Broadland District Council and South Norfolk Council Response to Examining Authority's Written Questions (ExQ1)

Deadline D2 (14th September 2021) (Extended 23rd September 2021)

HAZARD REF	BRIEF DESCRIPTION OF HAZARD:-
F02	WORKING NEAR OVERHEAD POWER LINES

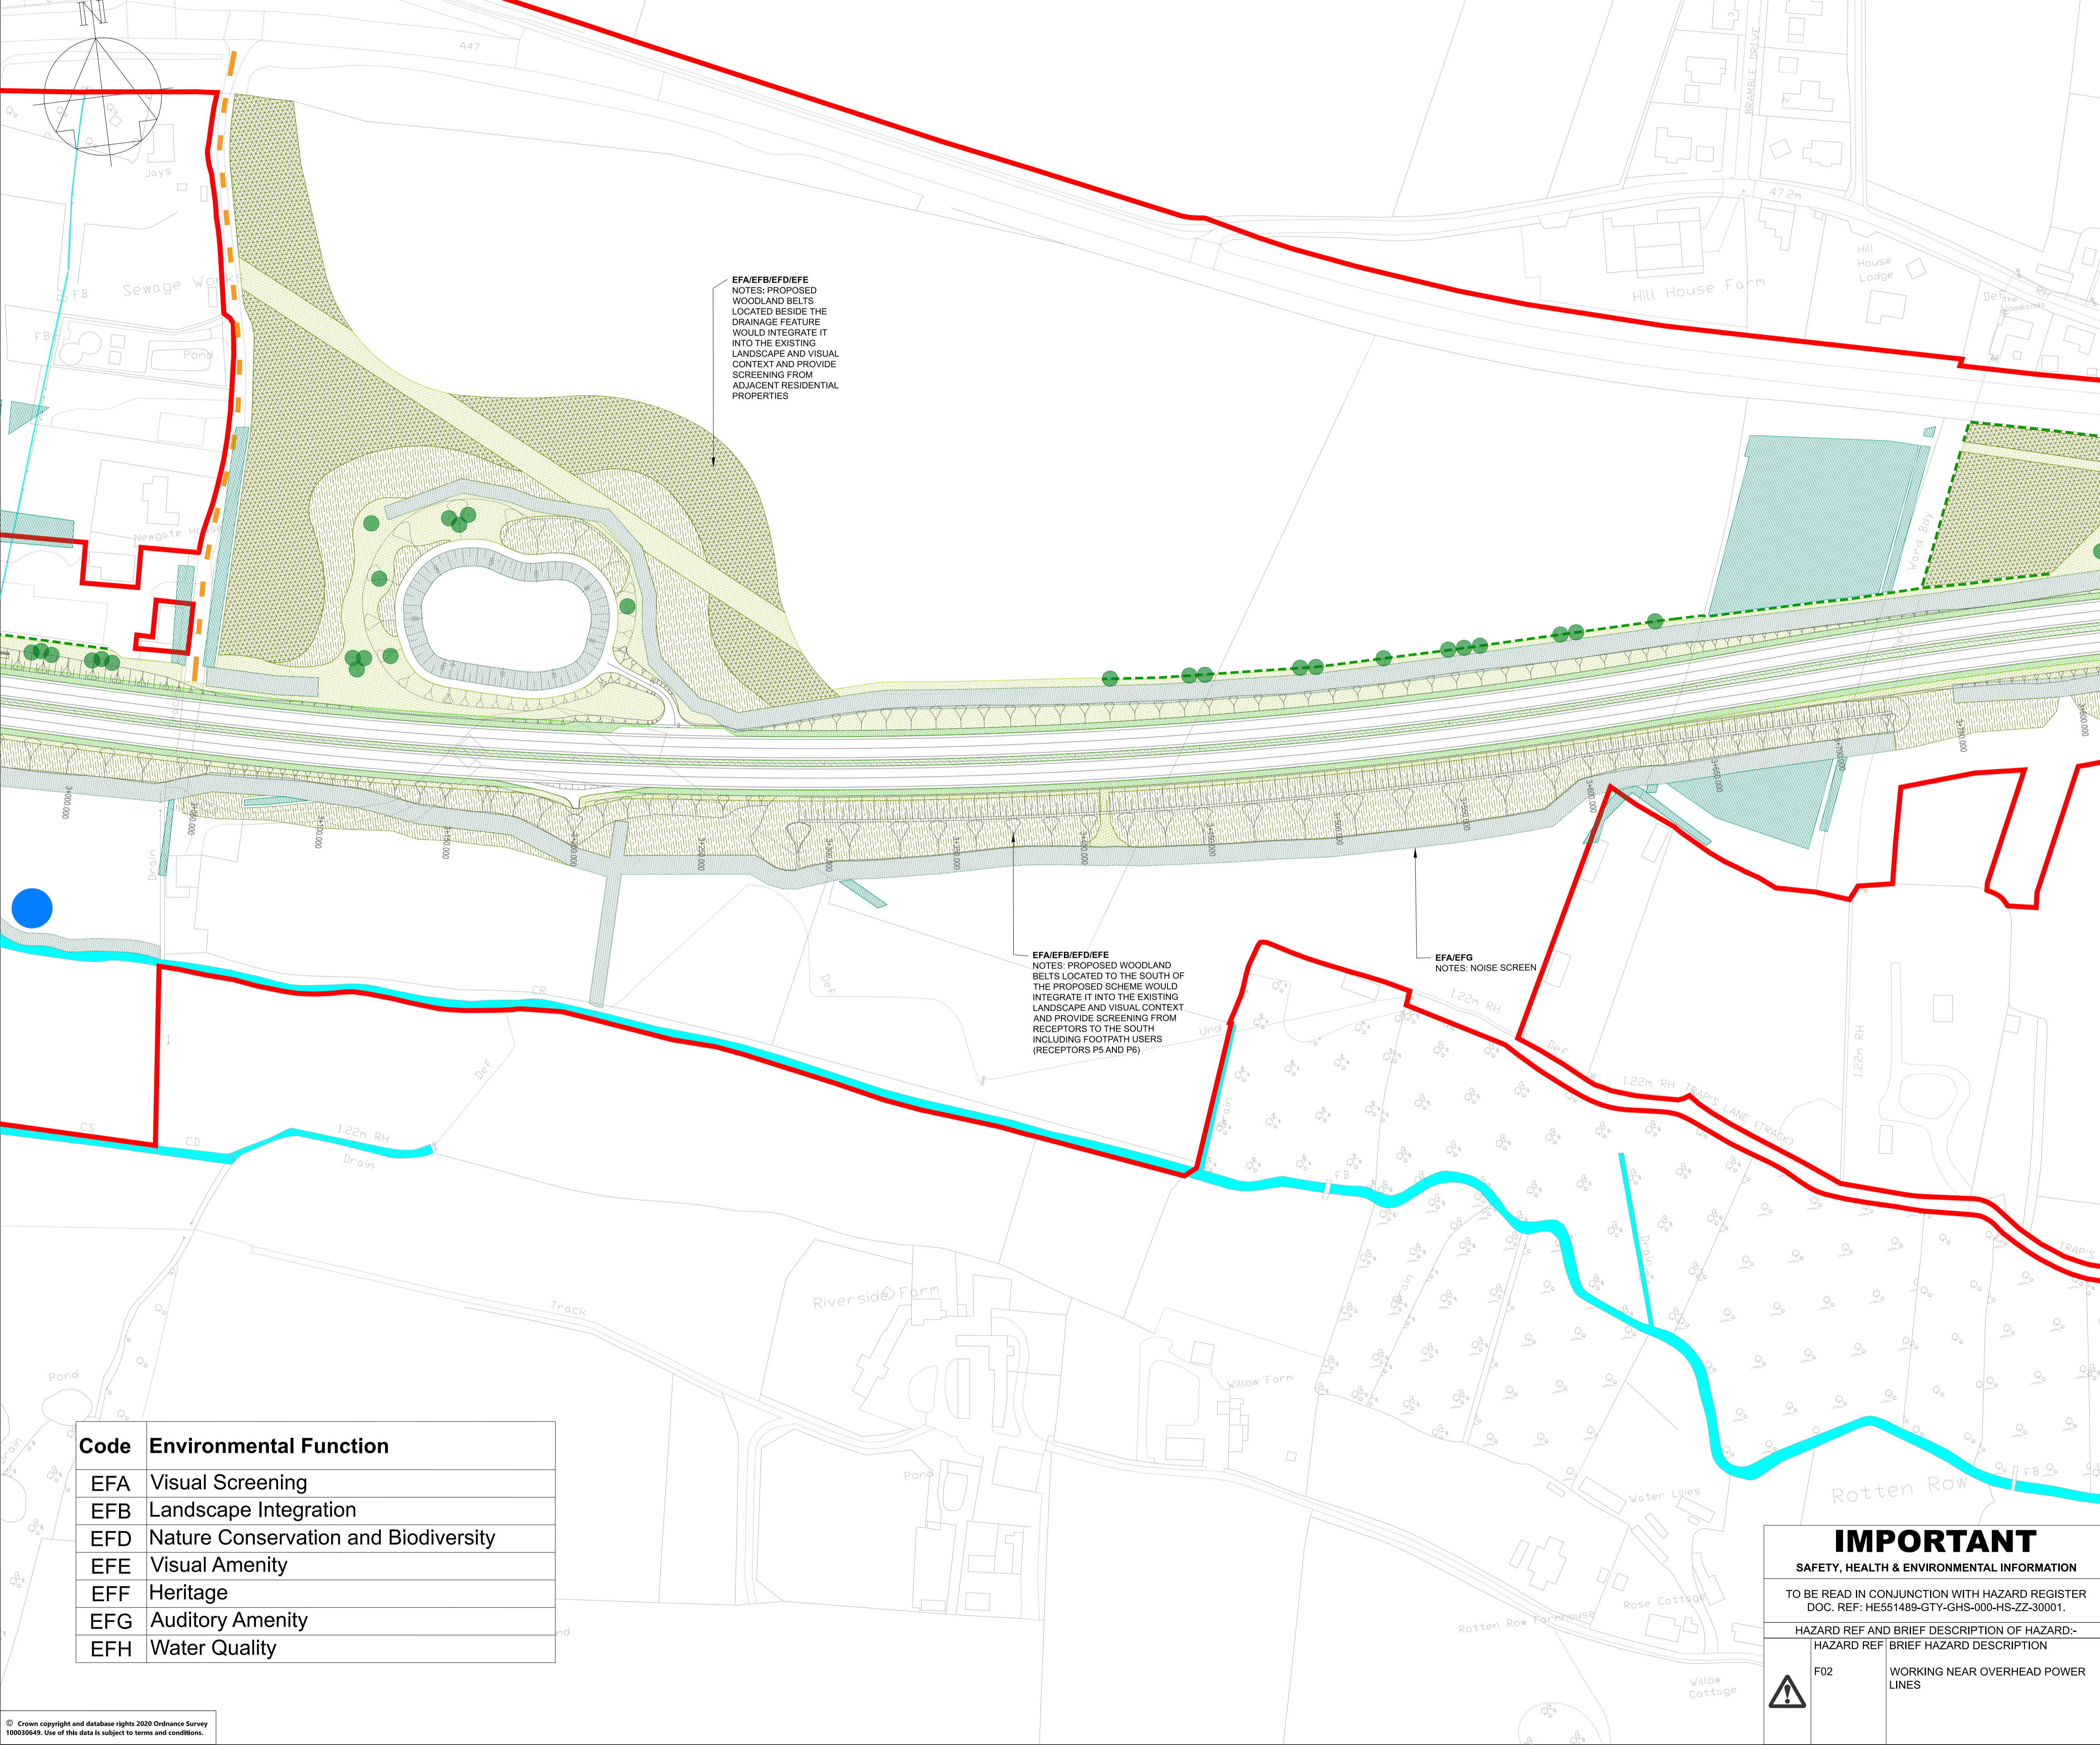
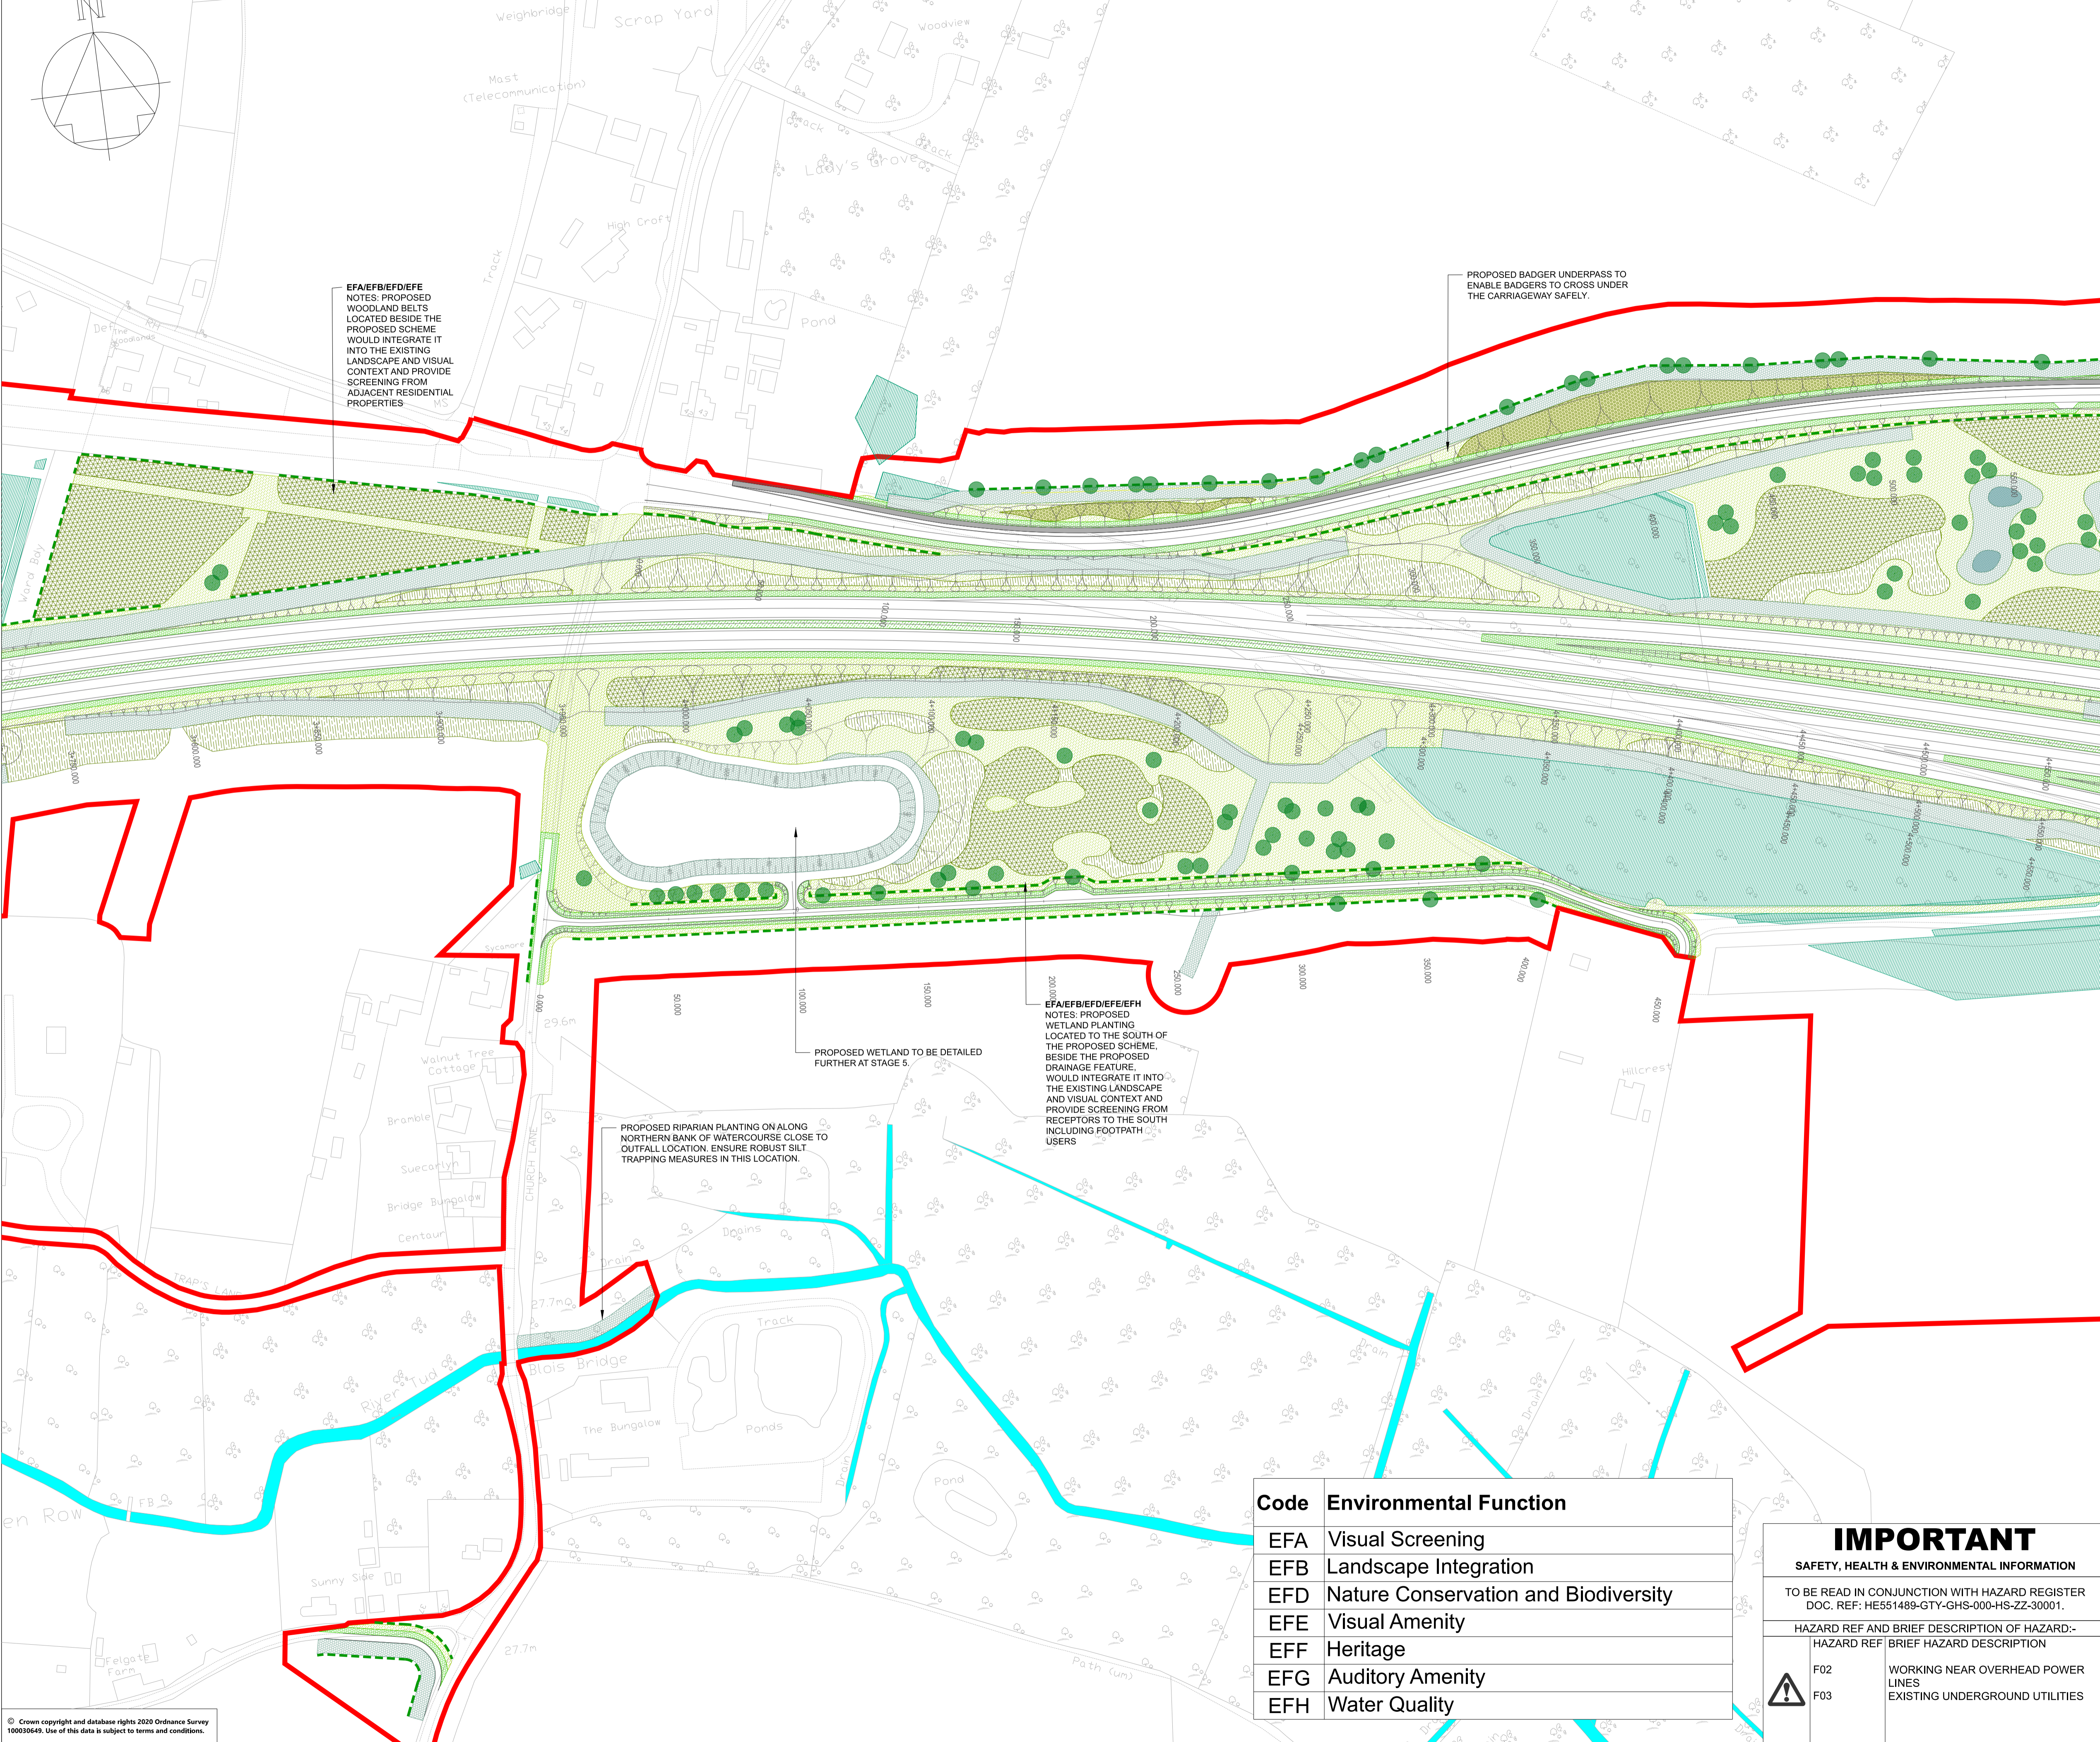
10.0.2	Are the parties satisfied with the Environmental Masterplan [APP-138] and the indicative proposals shown for the Proposed Development?	<p>These remarks were offered previously, but do not appear to have been considered:</p> <ul style="list-style-type: none"> • Reservations about the proposed formal approach to planting around the Eastern pedestrian/cycle bridge; this is not an urban area as the annotation suggests. • Will it be possible to view St Peter's Church Easton from the pedestrian/cycle crossing and/or its approach(es)? If not, is this desirable/possible? • What is the function of the spur of former Church Lane to the north of the proposed Easton pedestrian/cycle bridge? Is this necessary?
